Application Number: 2013-091 **Application Date:** 04/08/2013
CBL: 045 B023001 **Application Type:** Level III Site Plan Under 50,000 sq f
Project Name: Levell III Site plan/ Change of Use
Address: 91 STATE ST
Project Description: Renovation of existing building into 10 apartments. Change of Use from "convalescent home" to multi-family residential.
Zoning: R6

MEMORANDUM

Subject: Application ID: 2013-091

Comments Submitted by: Marge Schmuckal/Zoning on 5/7/2013

PROPOSED FLOOR PLANS
 A1.00

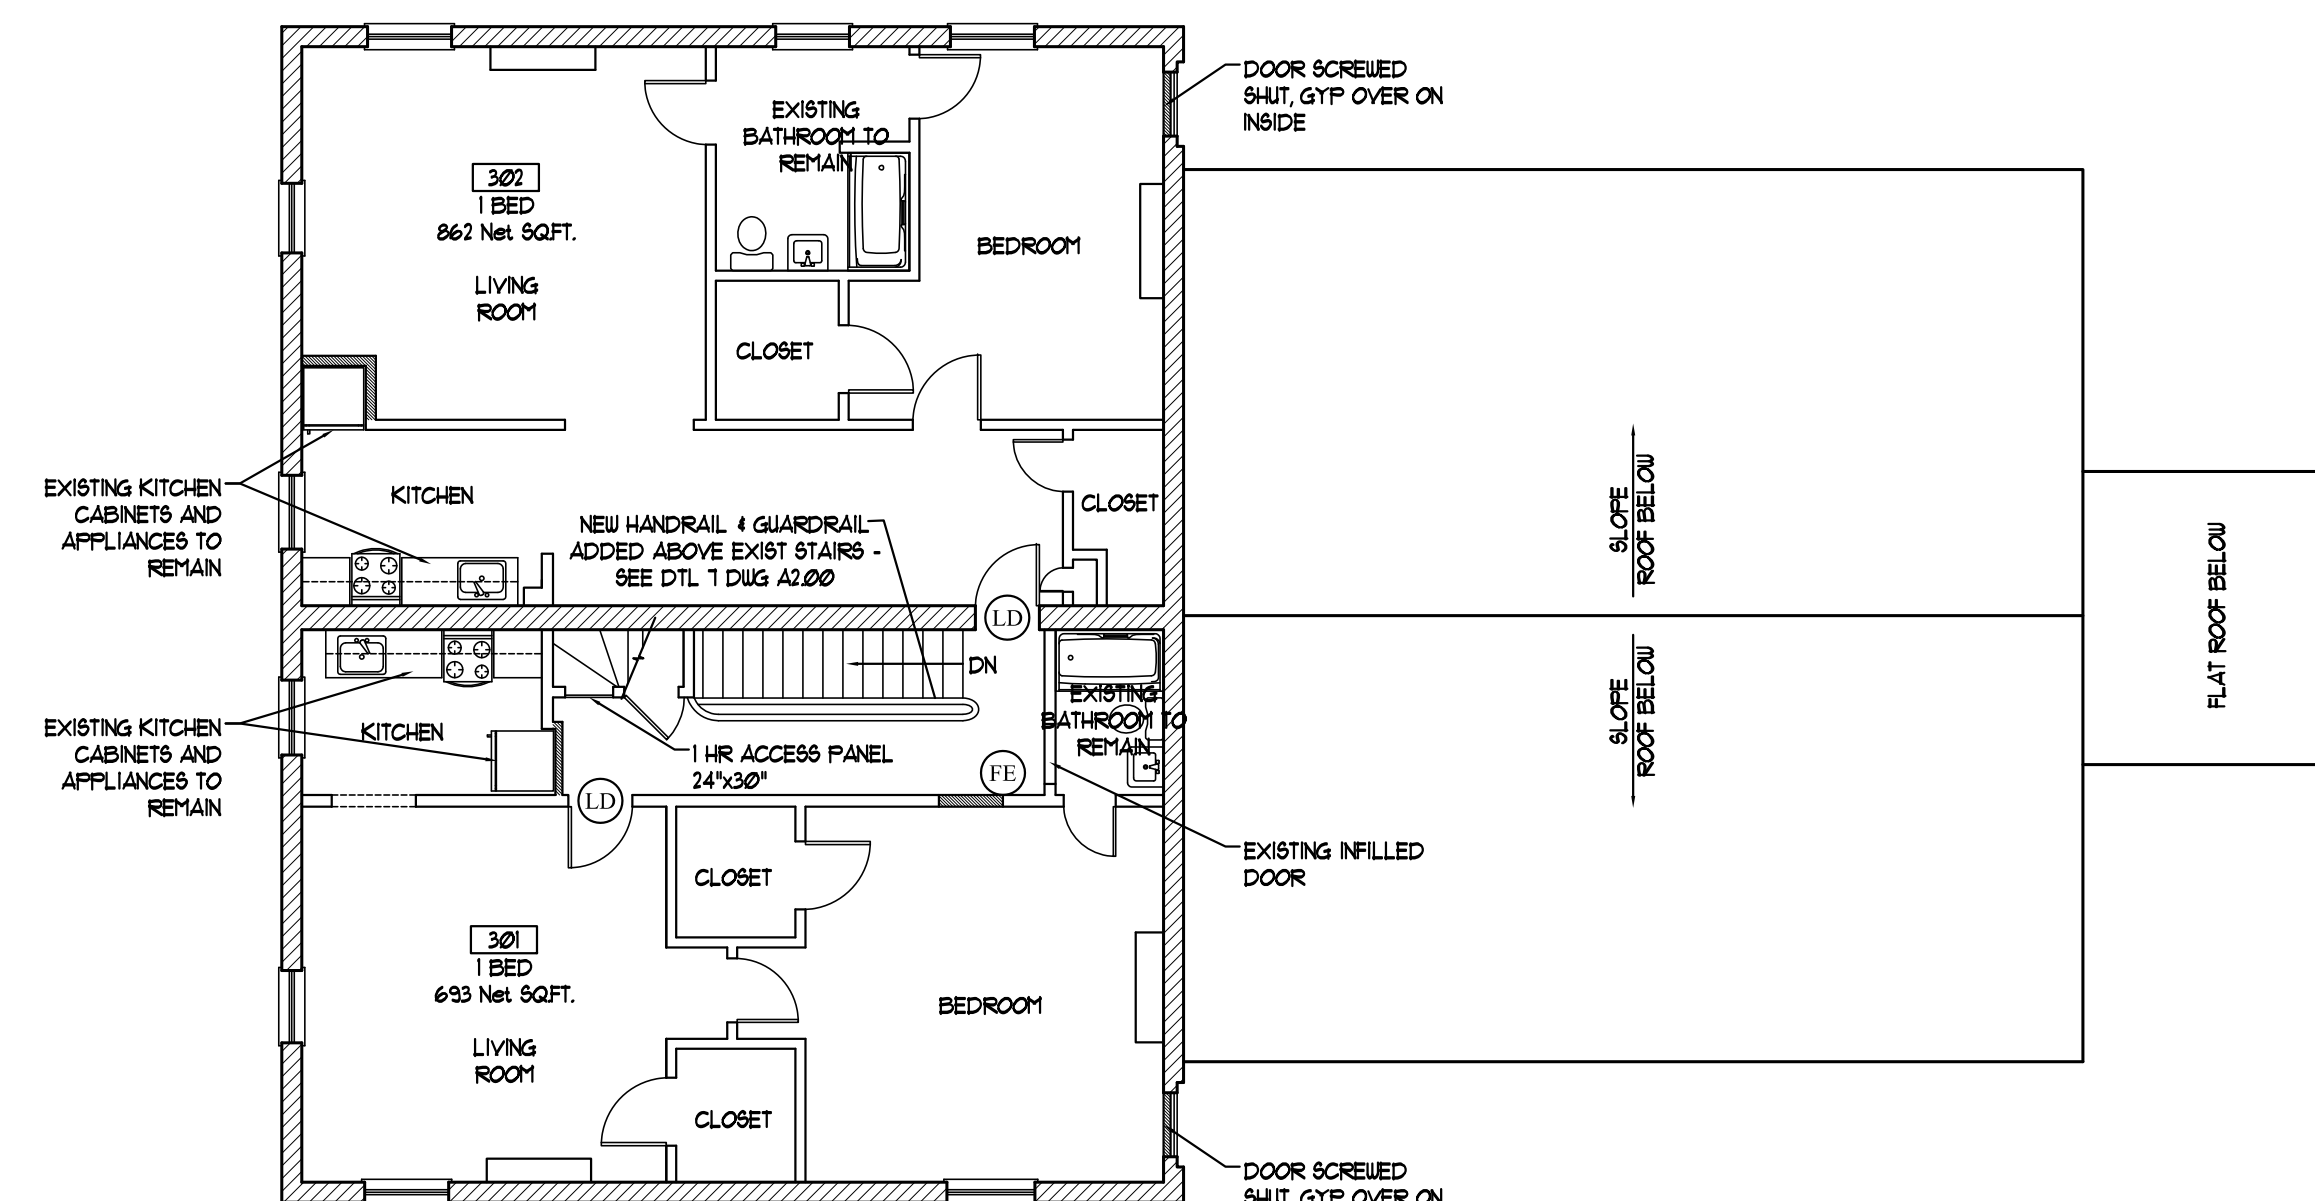
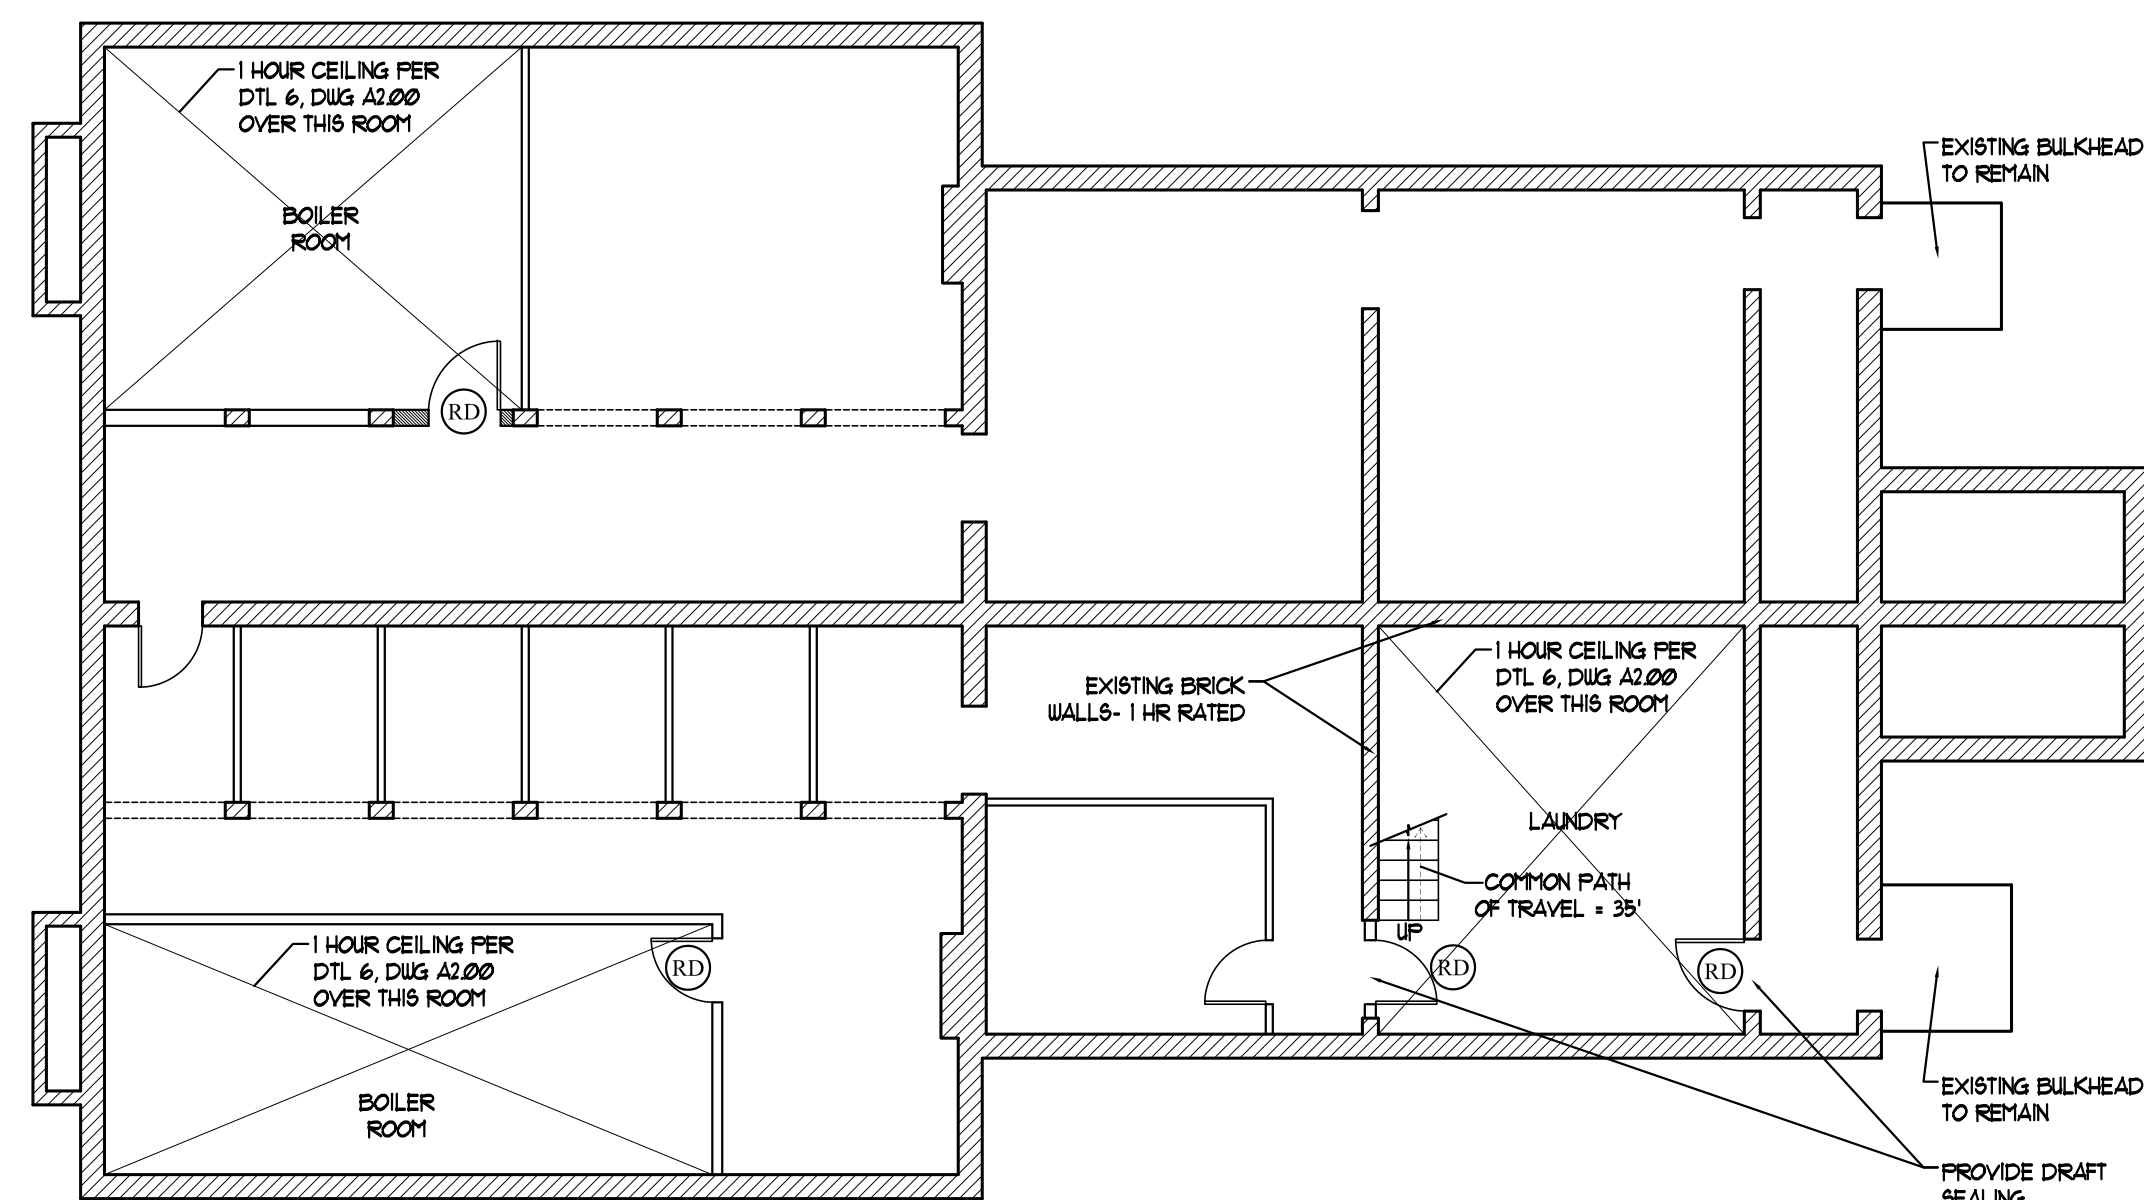
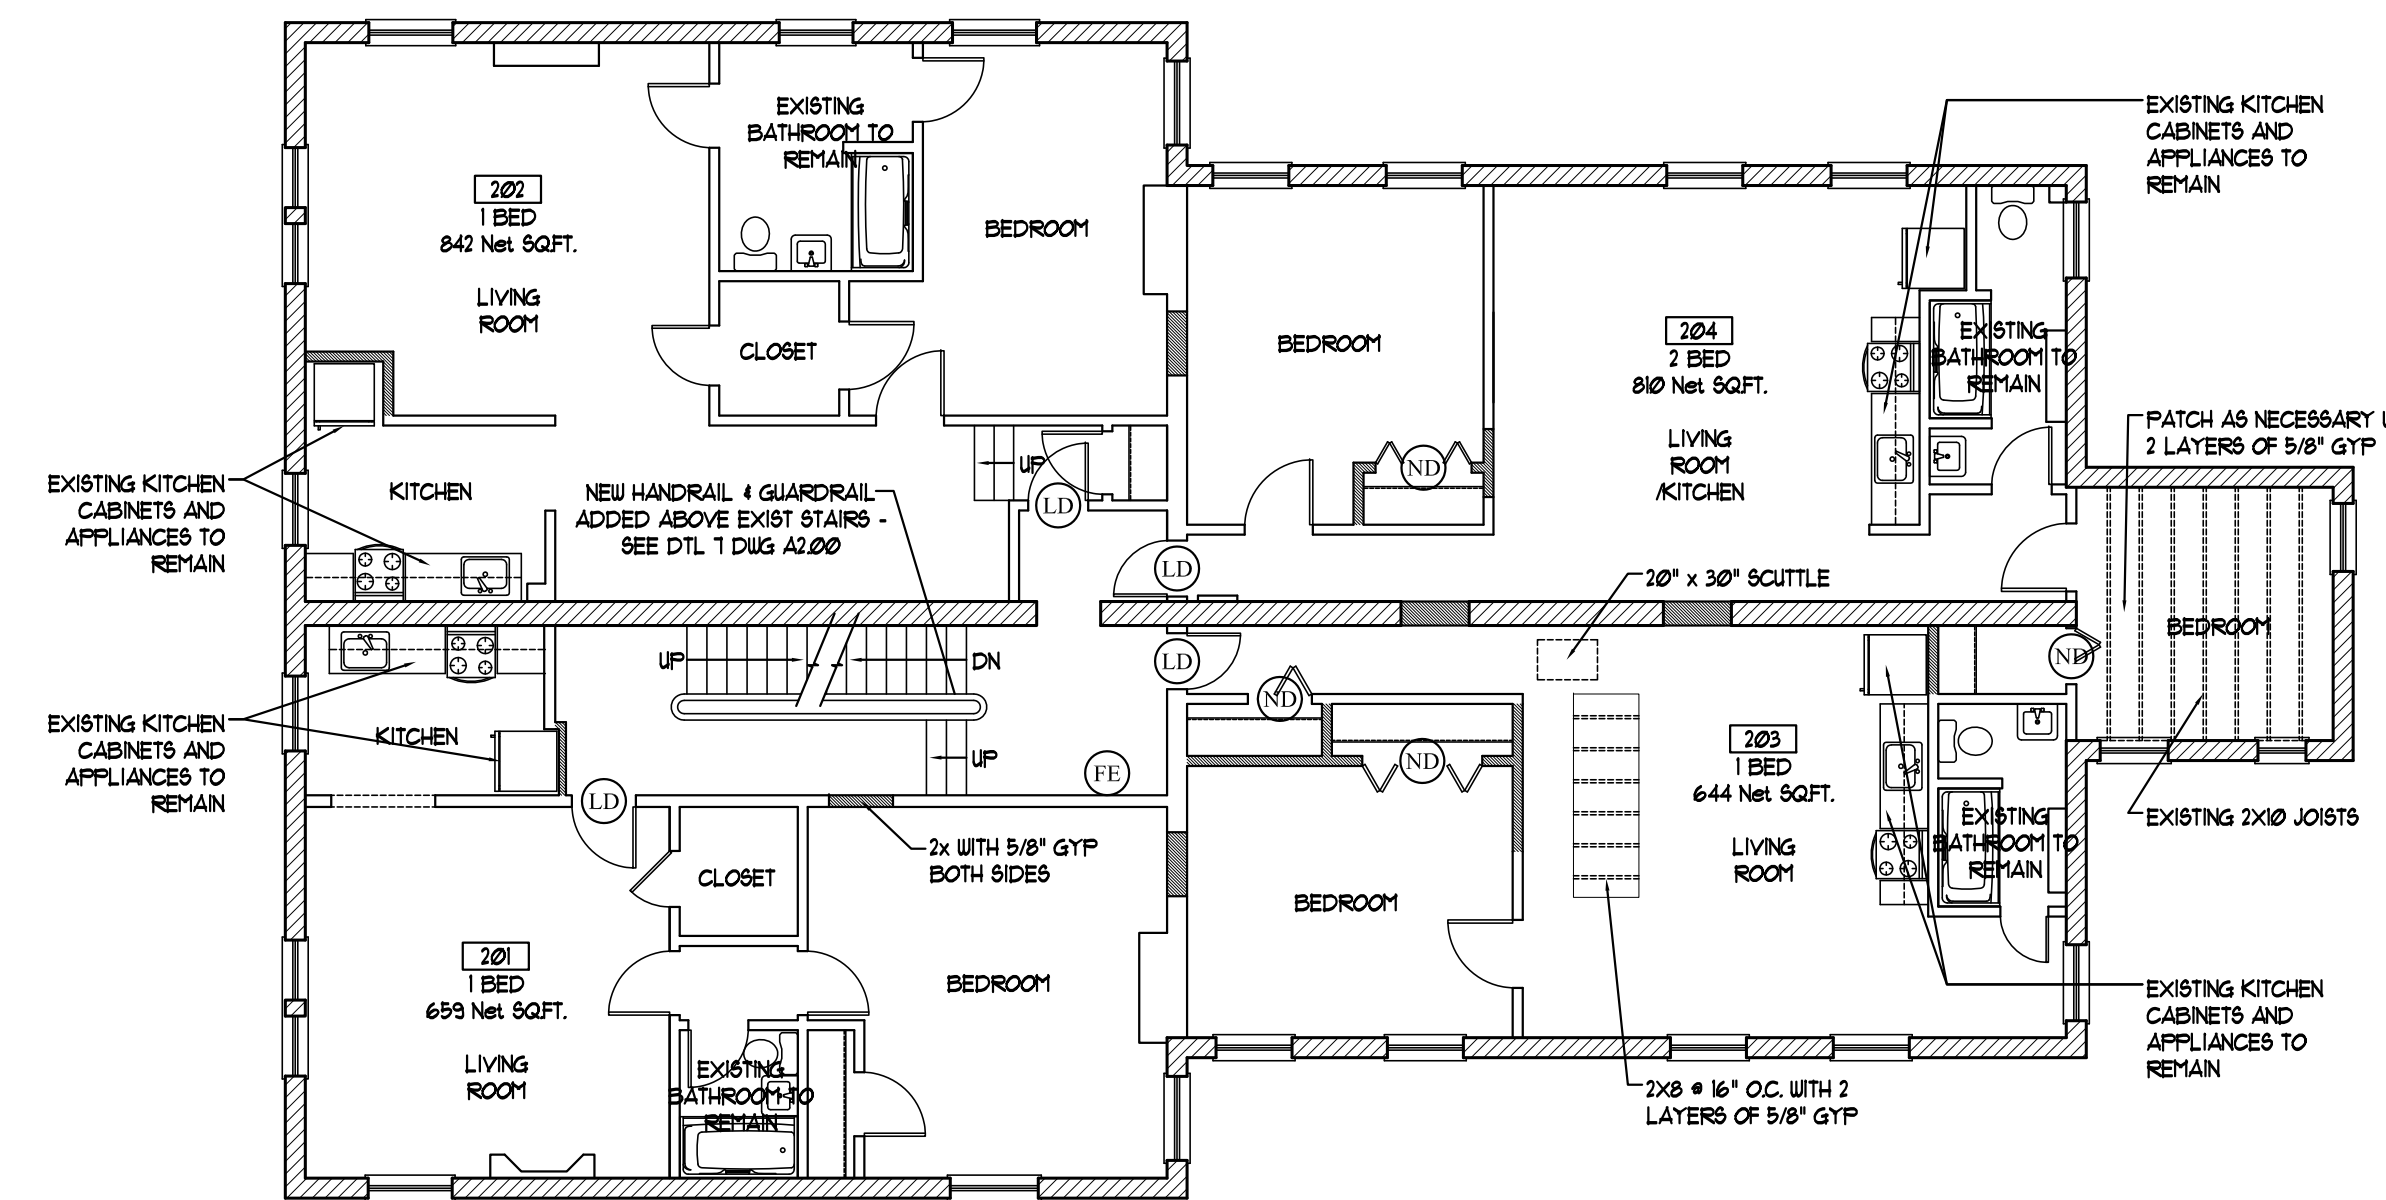
I have reviewed the most recent plans down loaded in e-plan. The latest floor plans confirm that the minimum 400 square foot for each apartment is being met. I have scaled the setbacks for the new porches. Section 14-142(a)3.b Of the R-7 Zone states that minimum setbacks for the side and rear is five (5) foot for each. My scaling of the plans show the Northerly side of the building to be less than 5' for a setback It would be in violation of the R-7 zone. The southerly side of the building shows a 6' side setback which meets the R-7 zone requirements. I would like the applicant to confirm the setbacks. There is no bar scale on the final site plan in which to completely calibrate dimensions. I acutally used the dlmensions of the building on the survey plan to calibrate on the final site plan. Again, I would want to see confirmation on the side setbacks. The minimum rear setback of 5 foot is more than being met.

I have reviewed the plans submitted for this proposal for a change of use from a convalescent home to 10 residential dwelling units. Thru a separate application, the applicant is also requesting a zone change from R-6 to R-7. Therefore I reviewed this submittal based upon the R-7 zone requirements. I have already stated that the land area per dwelling unit requirement of the R-7 zone is being met. I have checked the floor plans and the ten units are all meeting the minimum 400 square foot of apartment space. The smallest unit is approximately 610 sq foot in size.
